From: [Michael Flory](#)
To: [Dusty Pilkington](#)
Subject: RE: VA-16-00001 Mostofi
Date: Tuesday, September 06, 2016 11:17:27 AM

RE: VA-16-00001 Mostofi

VA-16-00001

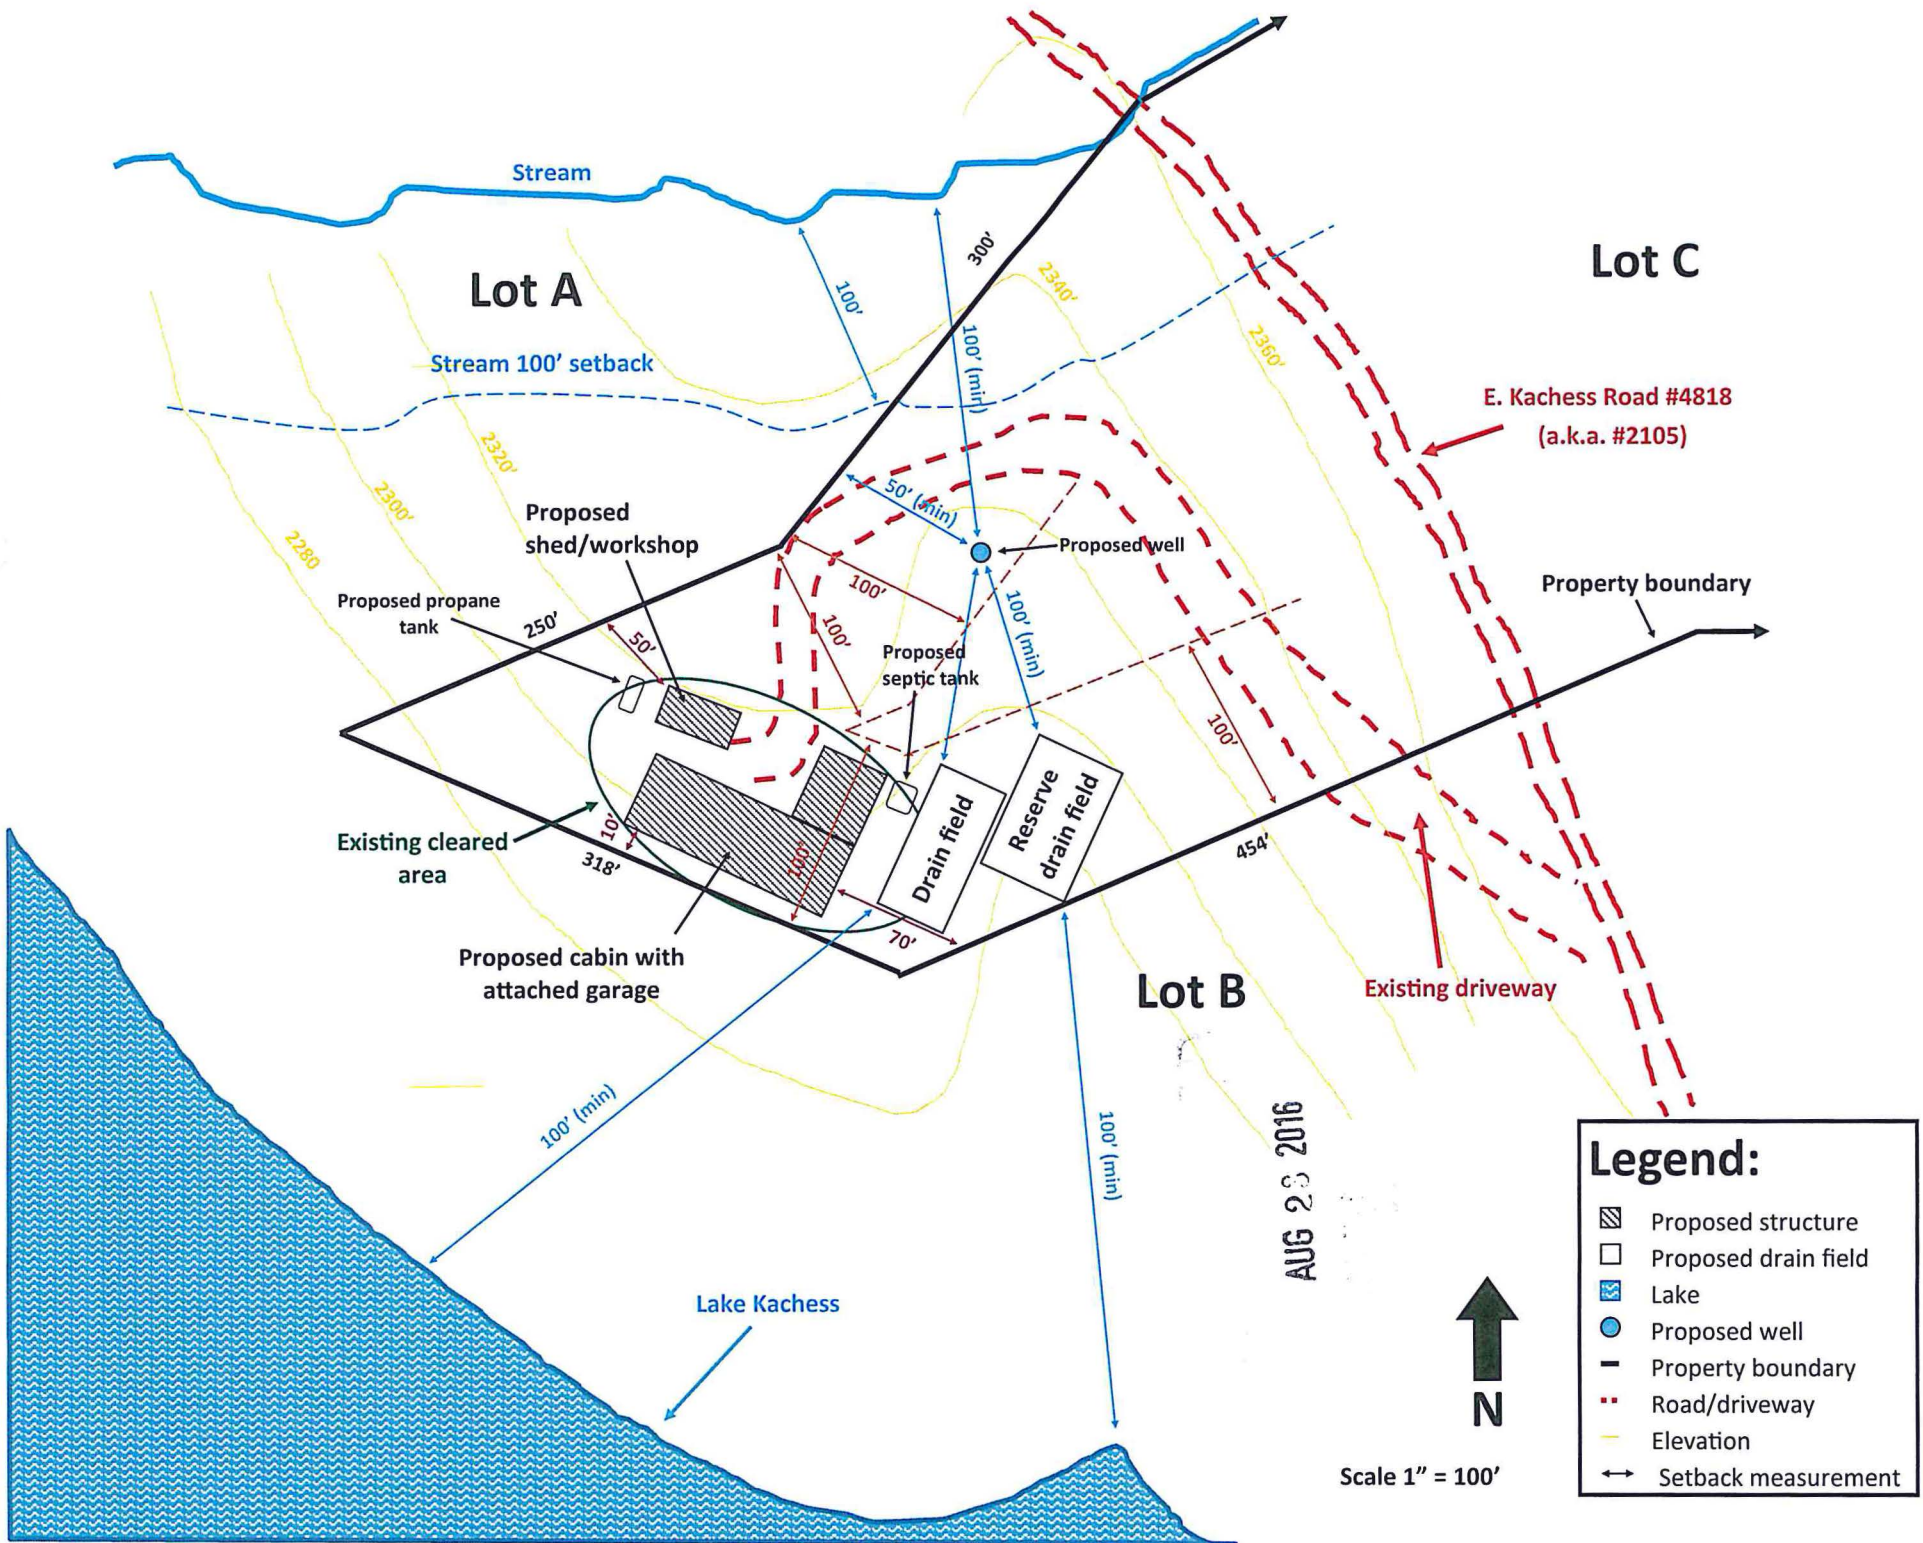
My only concern on this property is the grade. Getting a well drilling rig onto the property may be challenging and a drainfield cannot be installed on slopes greater than 30%.

1. The CDS Building Division has no objection for the applicant to encroach into the setback. Distance to be determined by Planning Division.
2. Due to steep slopes on the property, full geo-tech and soils report is required as well as engineered building plans.

After looking at your site layout and the topo maps, nearest I can tell, you may very well be building outside the steep slope area of your property. Our GIS mapping may not be entirely accurate so we like to error on the side of caution.

If you supply a good cross section of the property and proposed building foundation (similar to the attached picture) we could make the determination that you do or do not meet these requirements. If however our inspectors on site for the first footing inspection determine otherwise, if perhaps the building were moved or shifted too close to a setback, geo-tech could still be required.
